G-3837

Subject: Response to Shannon & Wilson Third Party Review
RE: Proposed Residence
5637 East Mercer Way, Mercer Island, WA 98040

<p>THE HEALEY ALLIANCE AZ 2505 N 25th DRIVE, GOODYEAR, AZ 85526 • (480) 444-6766 ARCHITECTS</p>	<p>Mi Treshouse, LLC, 5631 EAST MERCER WAY MERCER ISLAND, WA.</p>	<p>SITE PLAN DATE: 03/20/24 DRAWN BY: [Name] CHECKED BY: [Name] SCALE: 1" = 20'</p>
--	---	--	--

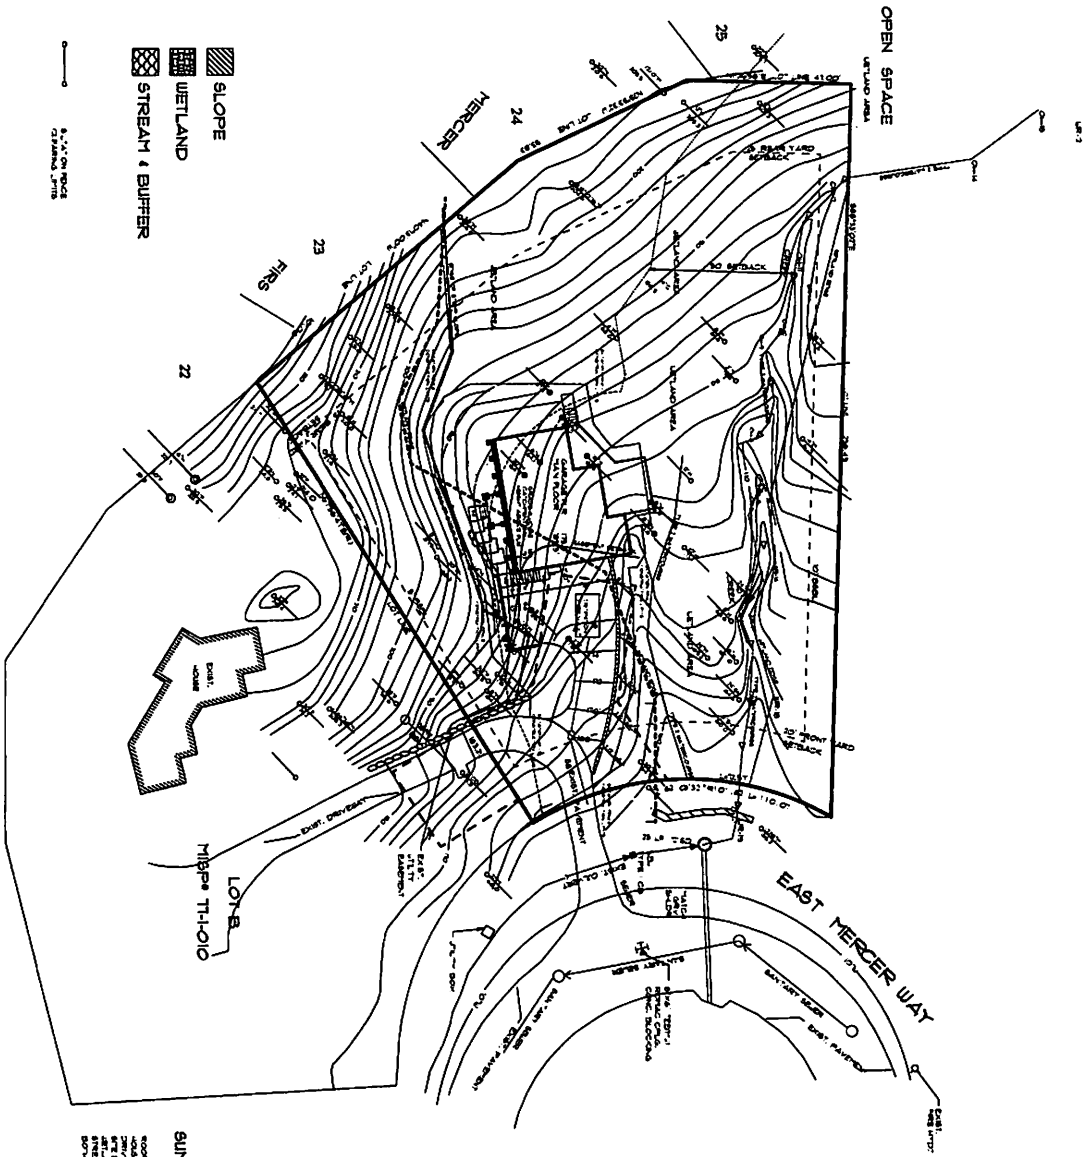
At your request, we have reviewed the revised location of the updated location for the proposed residence that places it 15 feet closer to the street in order to minimize impacts to the wetlands.

Moving the residence approximately 15 feet closer to the street has no impact on the projects potential geologic impact. Therefore, all previous opinions conclusions and recommendations remain the same.
